Description: Restoration of windmill and use of granary to provide museum/display/educational facilities and tea room

Location: Moulton Windmill
High Street
Moulton
Spalding Lincs

Amendment: Modern brick wall to be demolished
(Dwg. no. 49.11.A)

**TOWN AND COUNTRY PLANNING ACT 1990
NOTICE OF ACCEPTANCE OF AMENDMENT**

Orig. No. 49.11 Rev. A

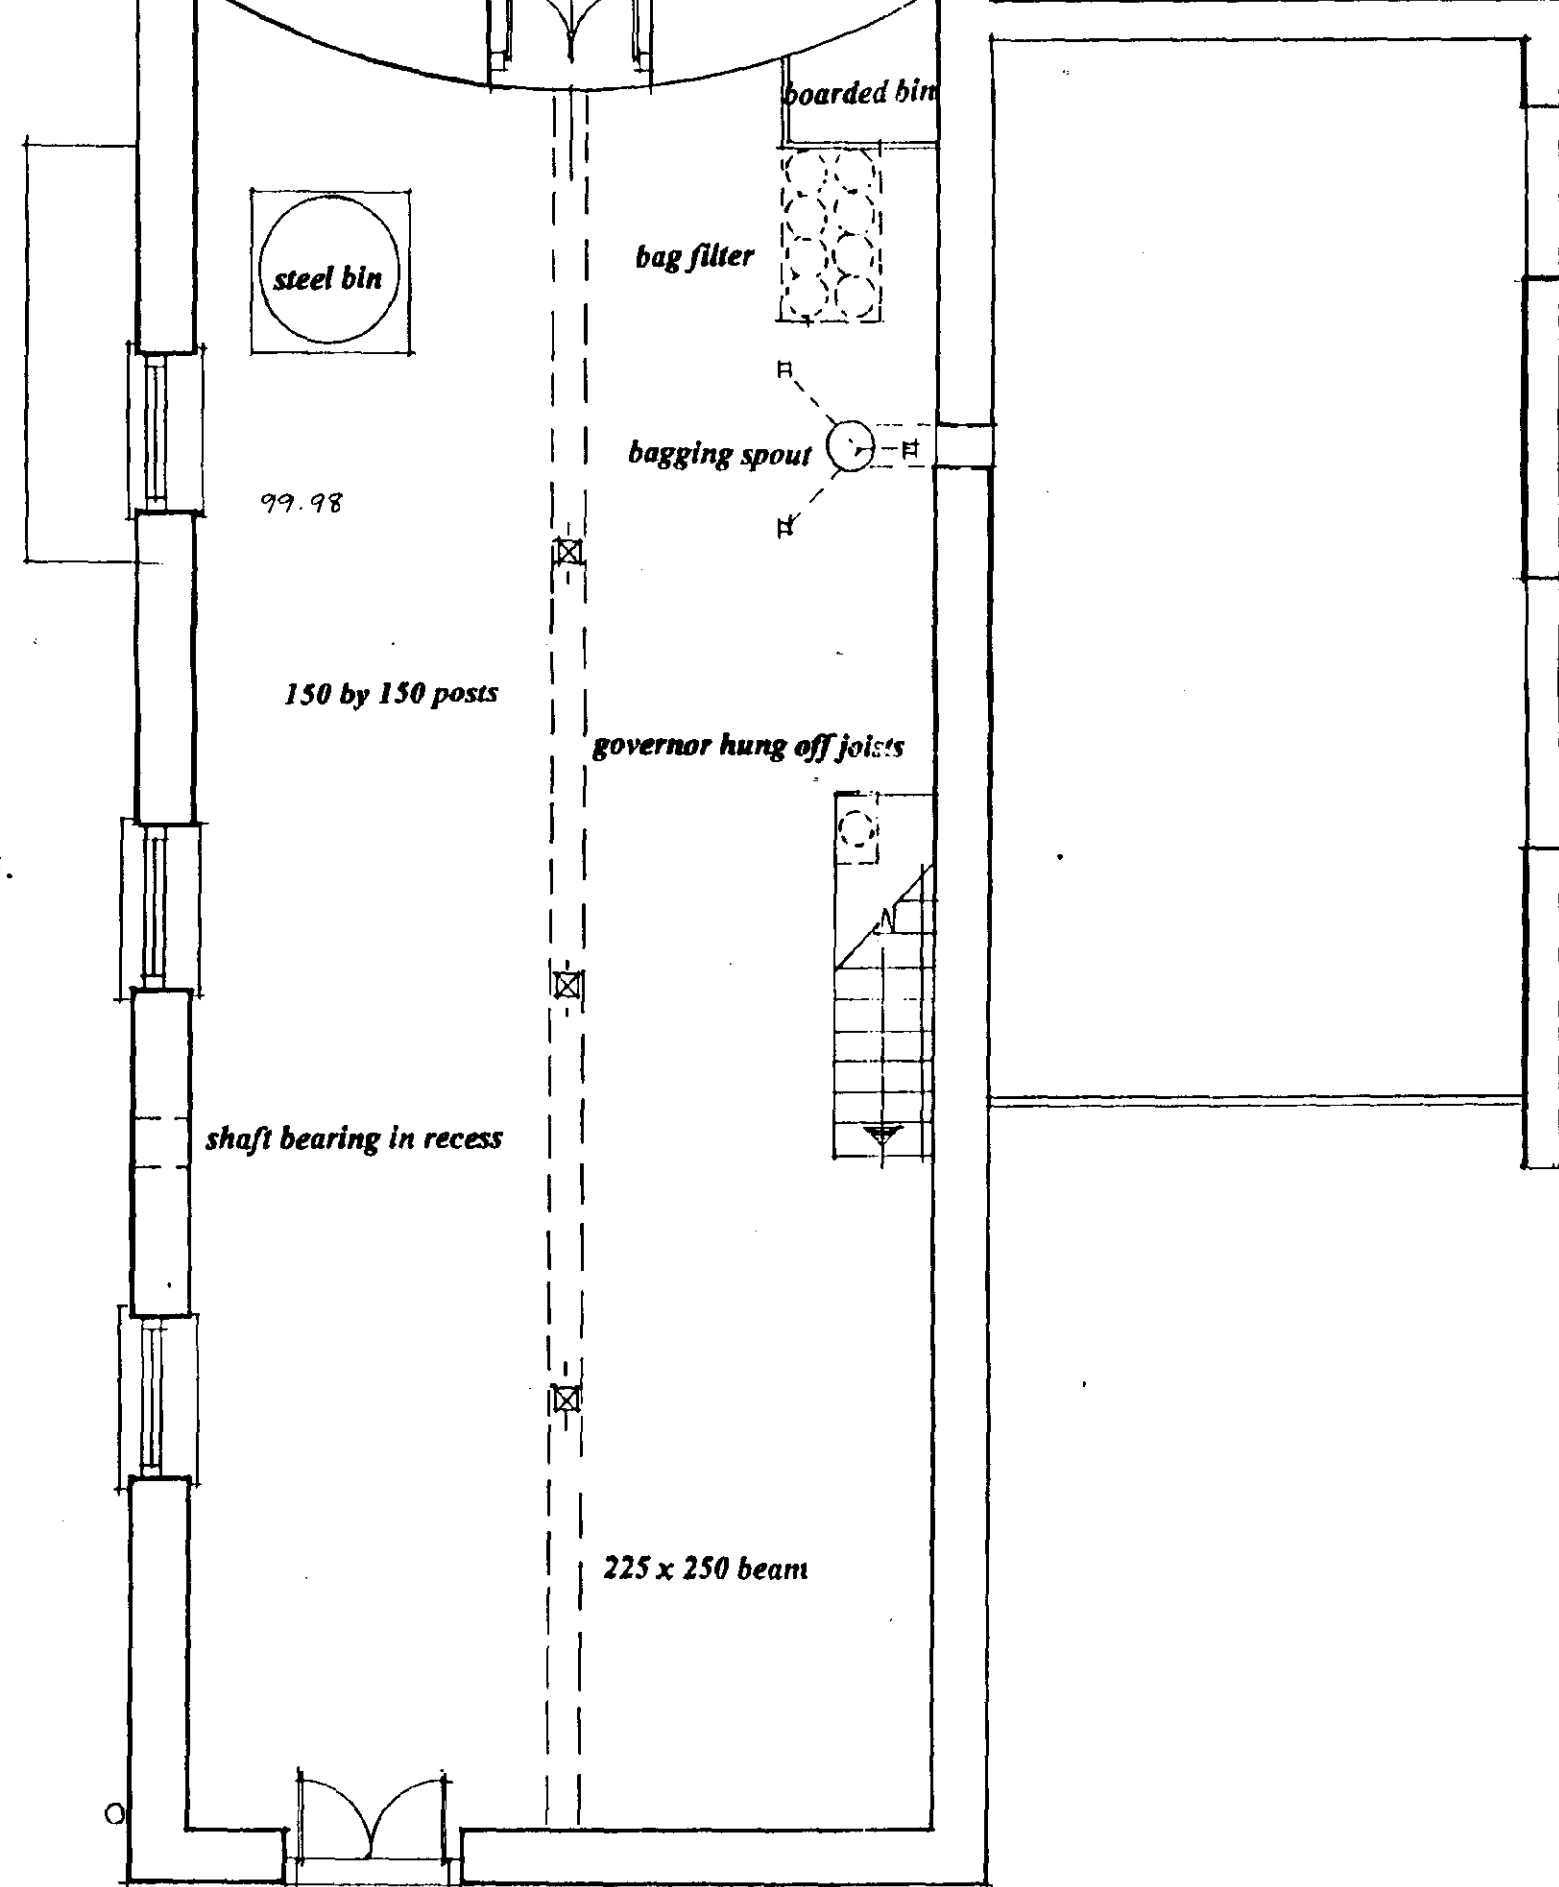
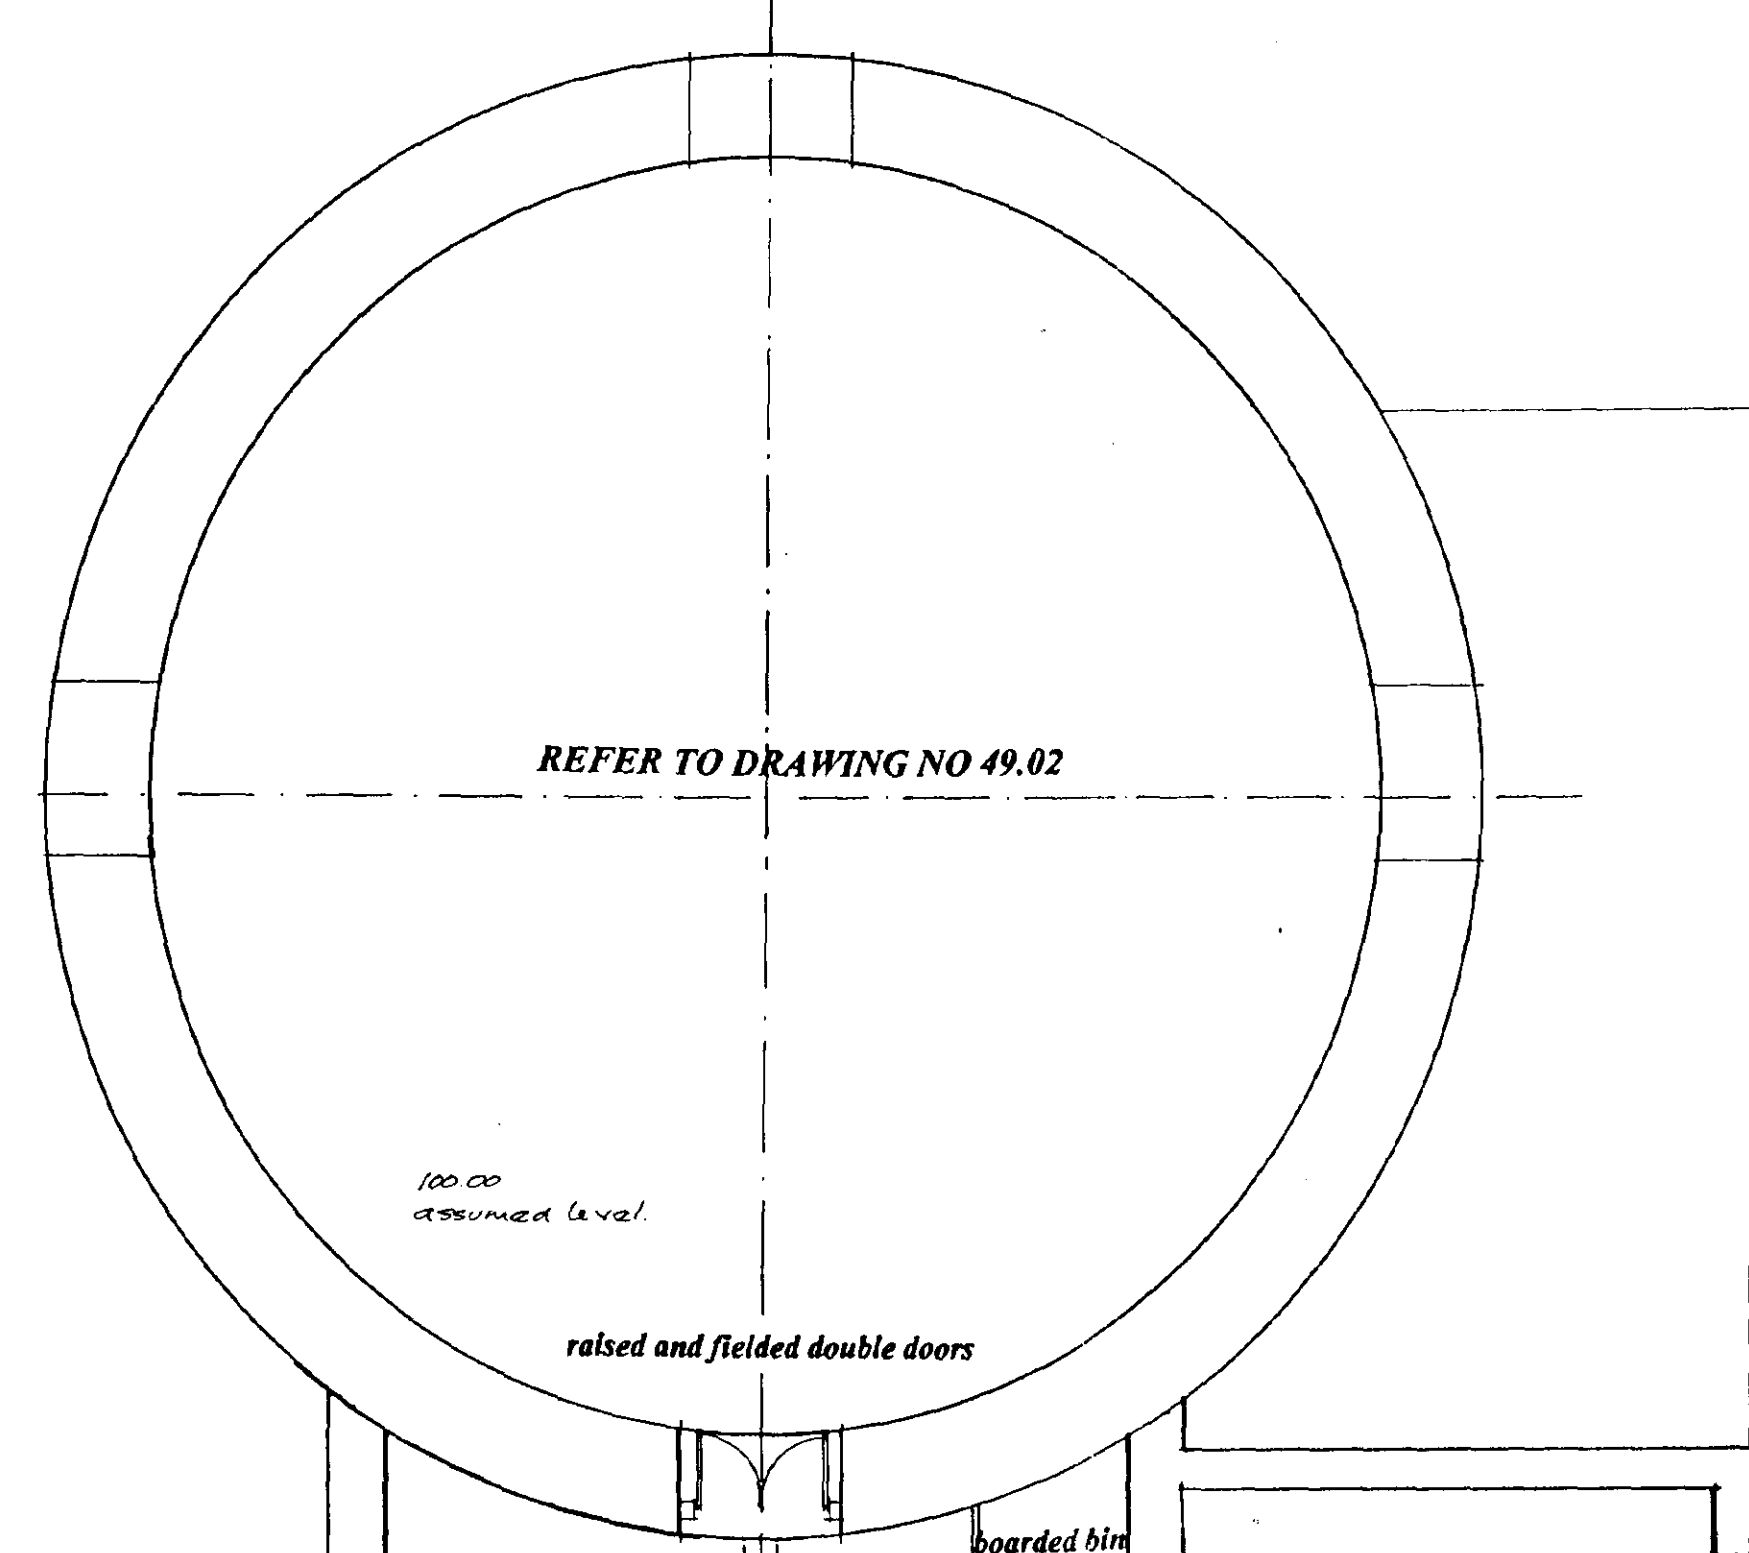
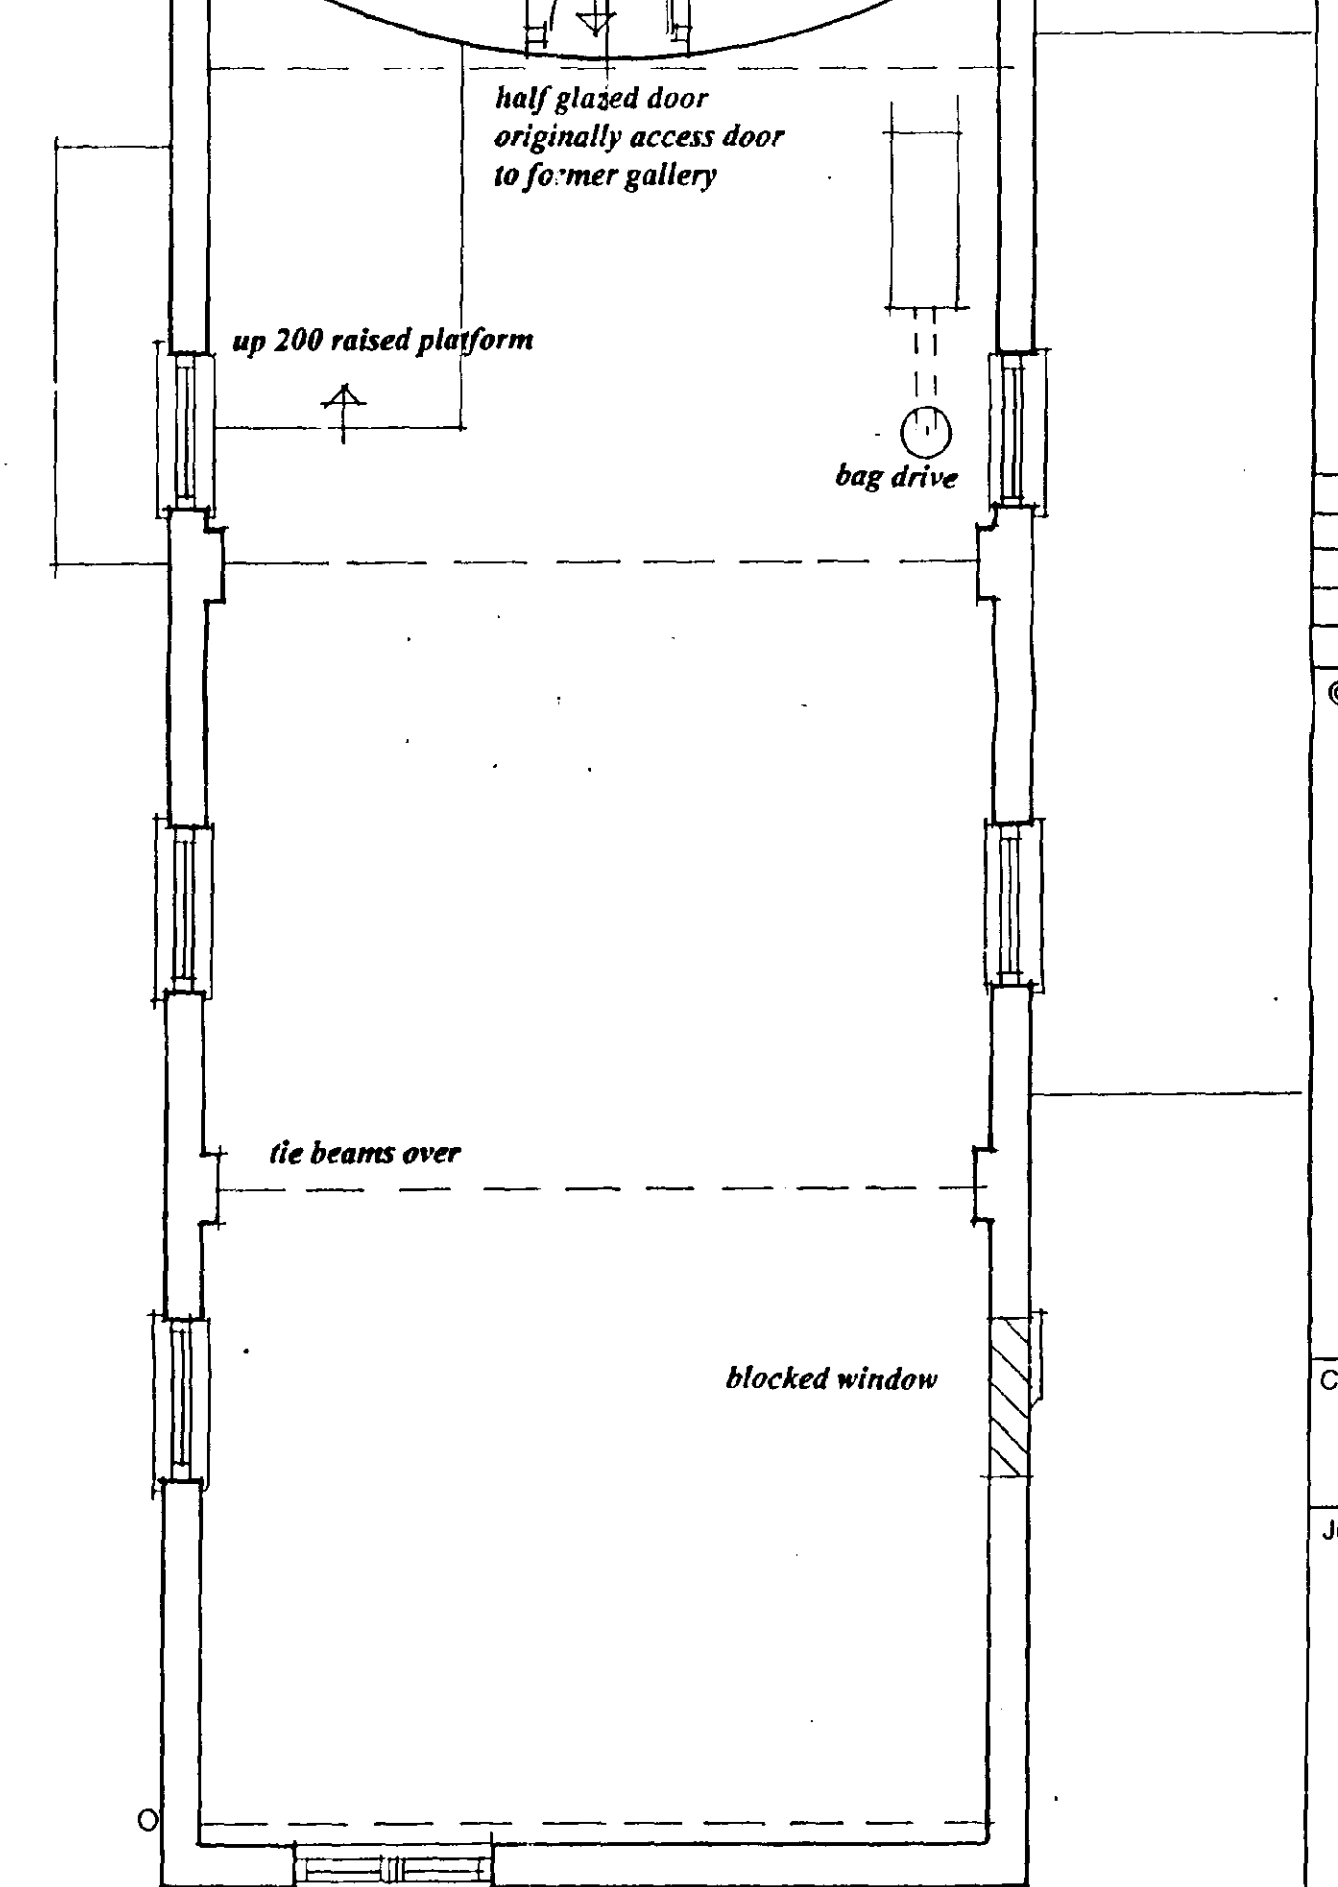
MODERN BRICK WALL TO BE DEMOLISHED - AS AGREED WITH JOHN BIGGADIKE
